**DEVELOPMENT REVIEW BOARD  
ACTION SHEET**

September 20, 2006

**DRB CASE NO/PROJECT NO: 1005148**

**RE: Minor Preliminary/Final Plat of Lots 22-A and 22-B, McDonald Acres, Second Unit,  
Project No. 1005148, 06DRB-01343**

PLAT OF
LOTS 22-A AND 22-B
McDONALD ACRES SECOND UNIT

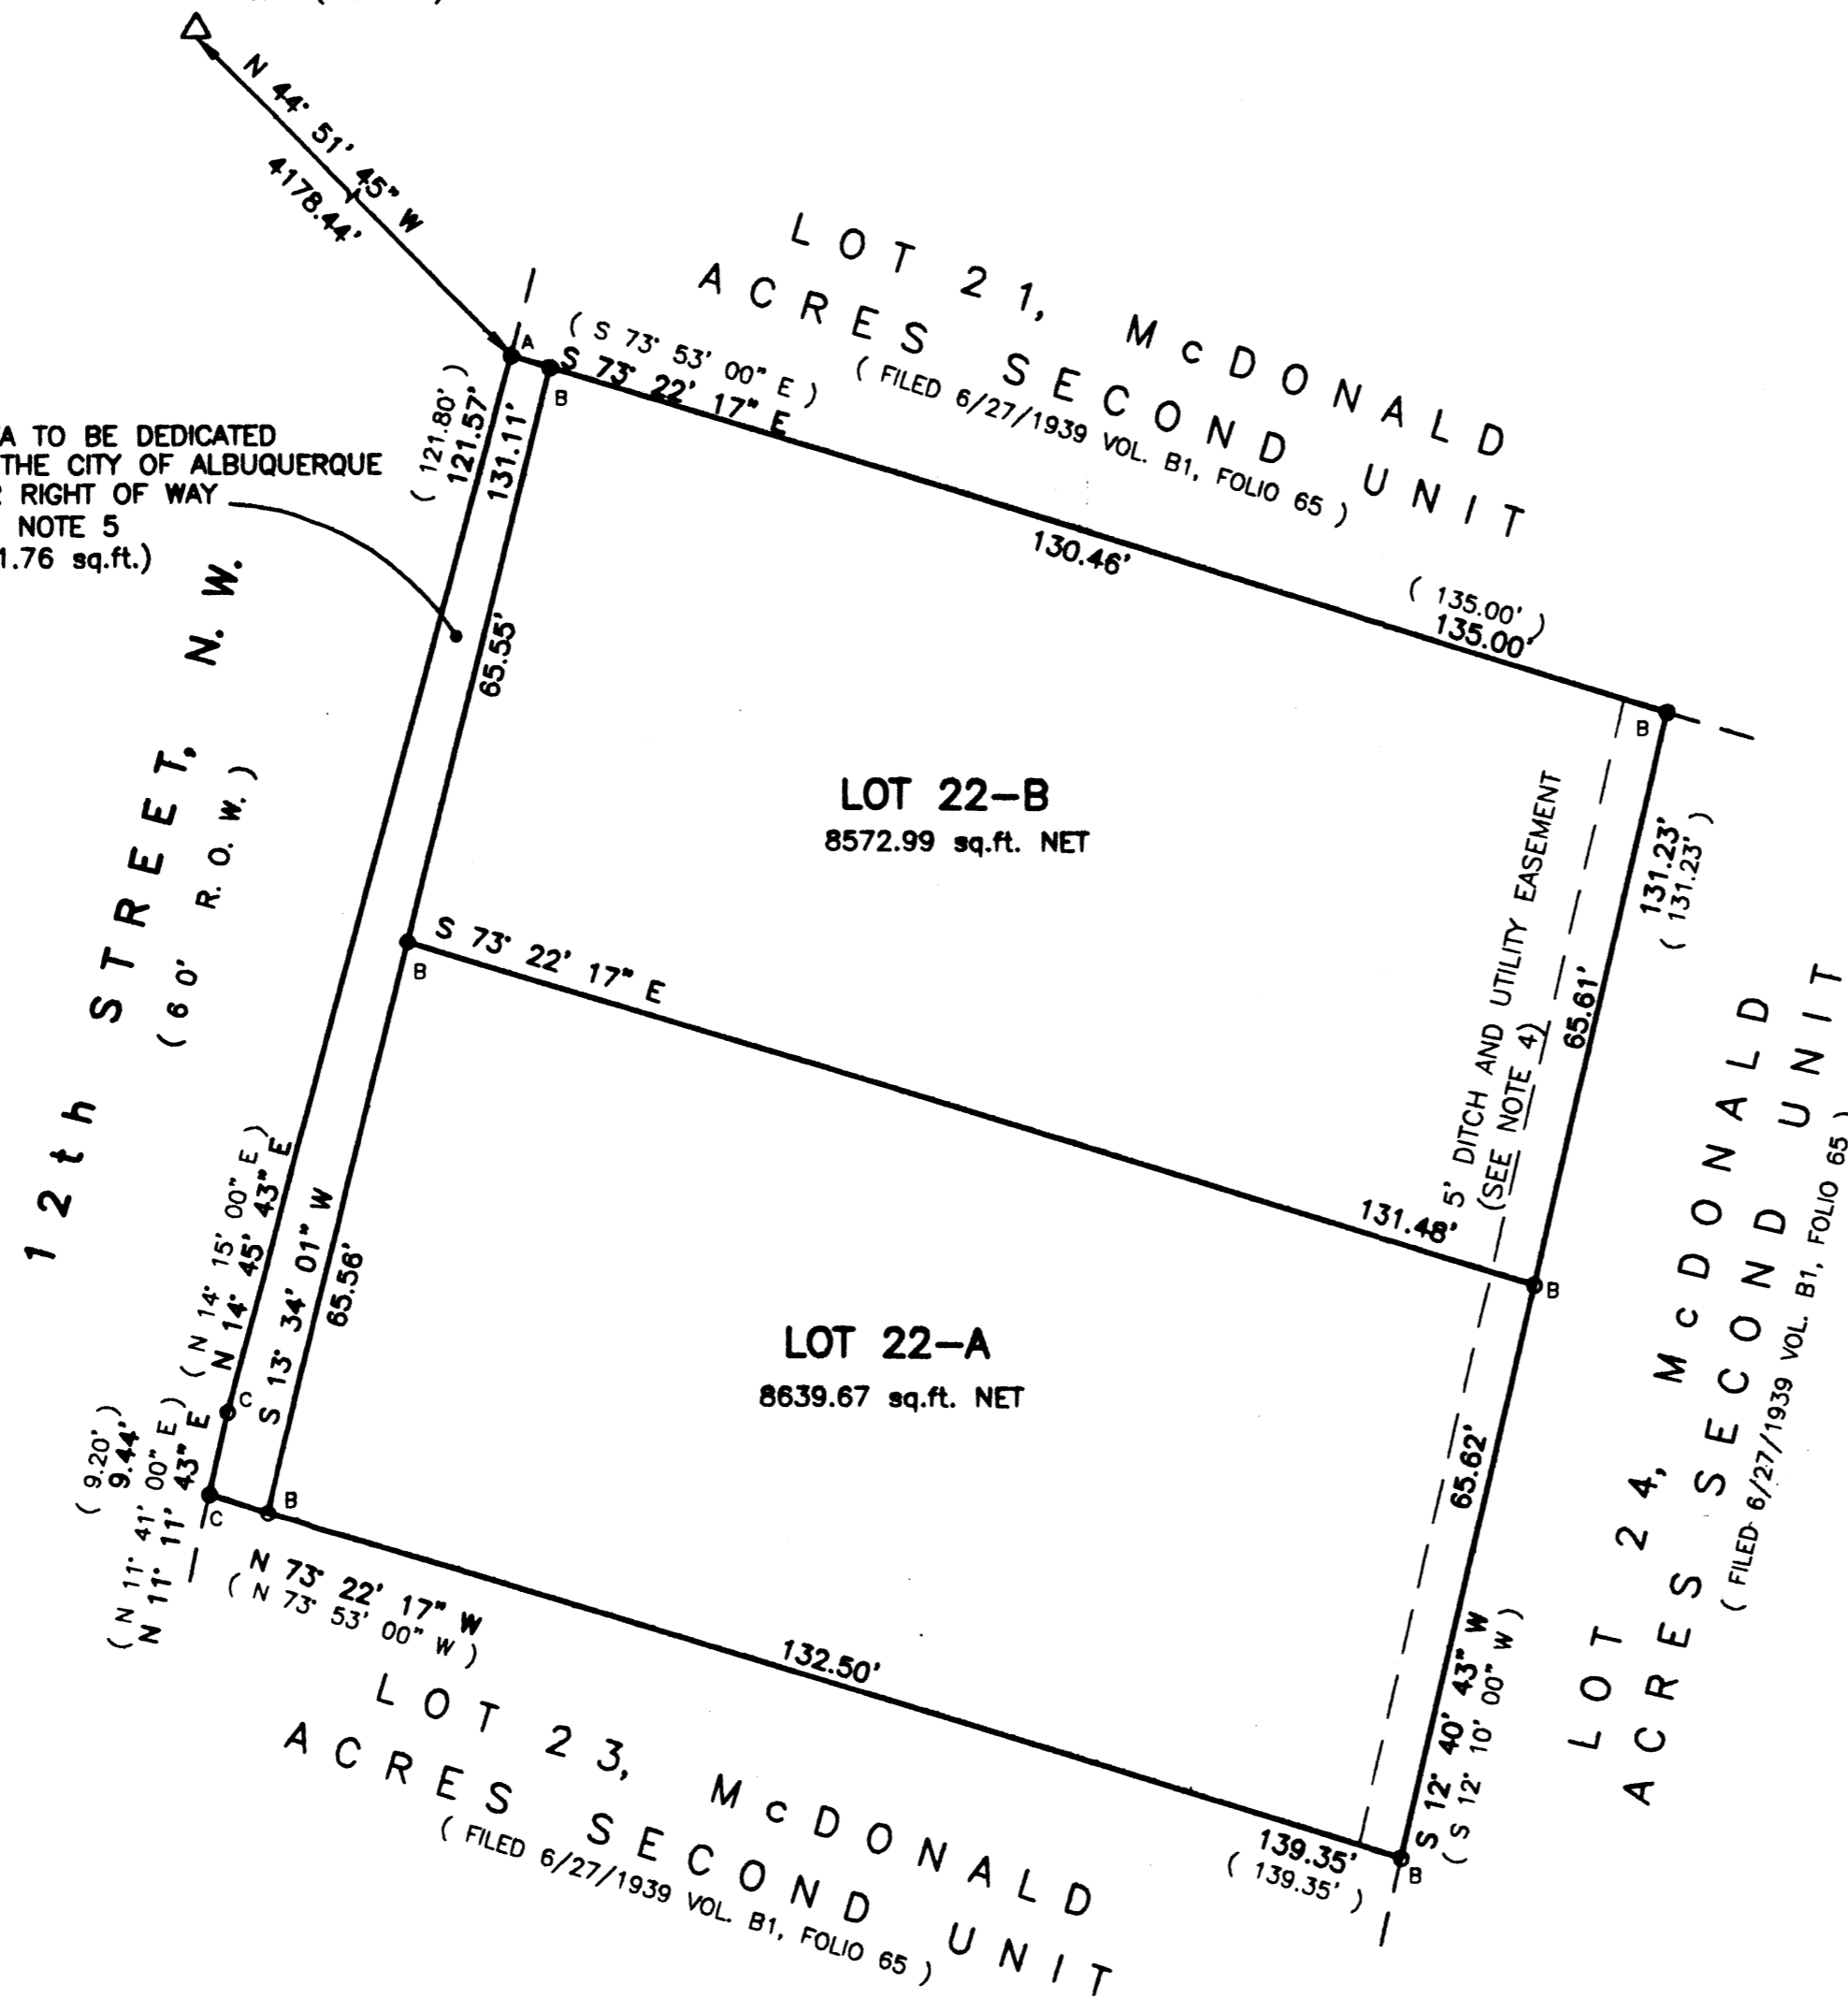
<u>No.</u>	<u>Comment</u>
1)	Will the two lots share a common drive?
2)	The DPM requires a 13' dedication from the face of curb. This allows a 6' planter area and a 6' sidewalk.
3)	Standard infrastructure per DPM is required. (6' sidewalk)

1. No new lots are being allowed along 12<sup>th</sup> street because there are no water or sewer lines available for new service connections. The existing 30" water line and 48" sewer line int 12<sup>th</sup> Street can no be tapped. Old existing homes were connected to these lines when these lines were constructed and it was pre-existing development. Subdivision will require design and construction of a 6" water line and 8" sewer line in 12<sup>th</sup> at the expense of the subdivider.
